**Consultation Response from Alan Smith,
KC Waste Strategy (Refuse & Recycling)**

2024/92848 Marsh Carpets, 82-84, Westbourne Road, Marsh, Huddersfield, HD1 4LF

Date Responded: 13/11/2025

Responding Ref: WPS 25 058

Drawing
Proposed Floor Plans

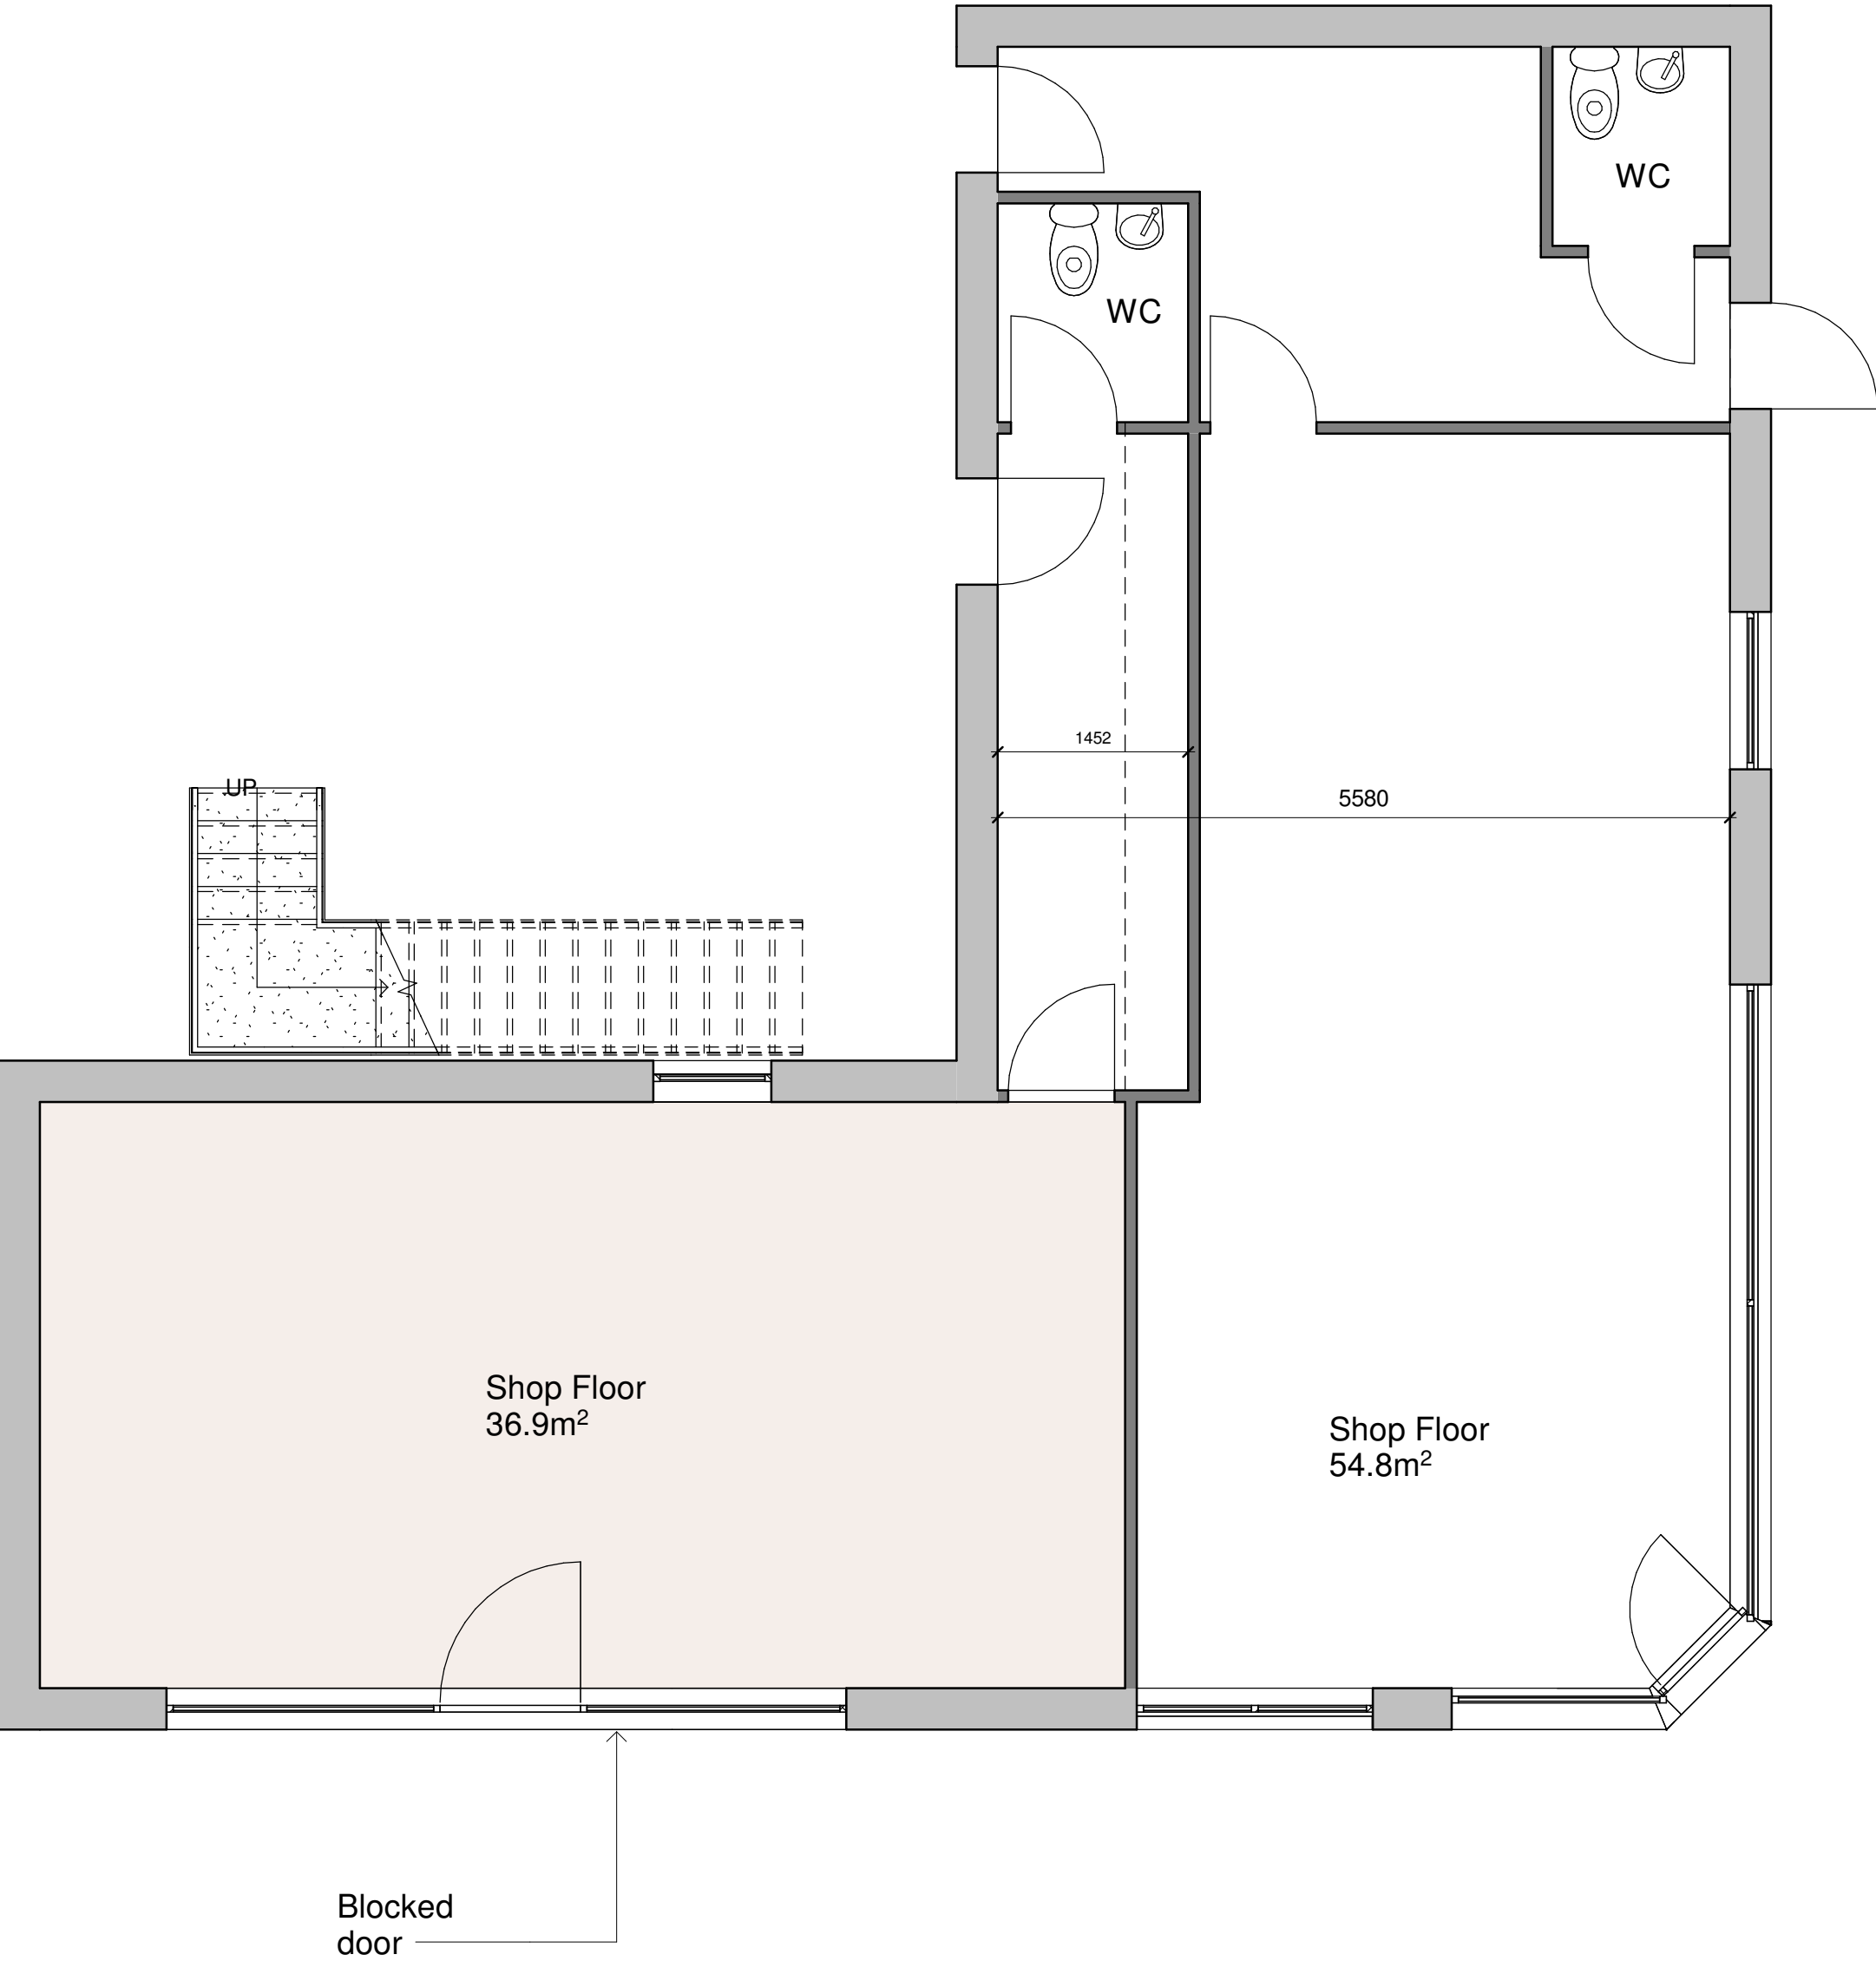
The drawing shows that 1 x 1,100L bin will be used for the commercial properties.

- **The proposed bin location still presents an unacceptable fire risk due to the proximity of the fire escape. The bin needs to be moved to a more suitable location or else a fire resistant bin store needs to be provided.**
- **Bin space dimensions:**
 - floor space required is 1,575mm x 1,1900mm per bin
- **Bin storage location:**
 - Must not obstruct highways or driveways
 - No gradients steeper than 1:12 or steps
 - Located at least 4m away from fire exits, doors and windows
 - Not located near or underneath fire escapes

- Where the container cannot be located 4m away from a property then it is necessary that the adjacent structure is fire resistant, which has a resistance to fire of 30 minutes
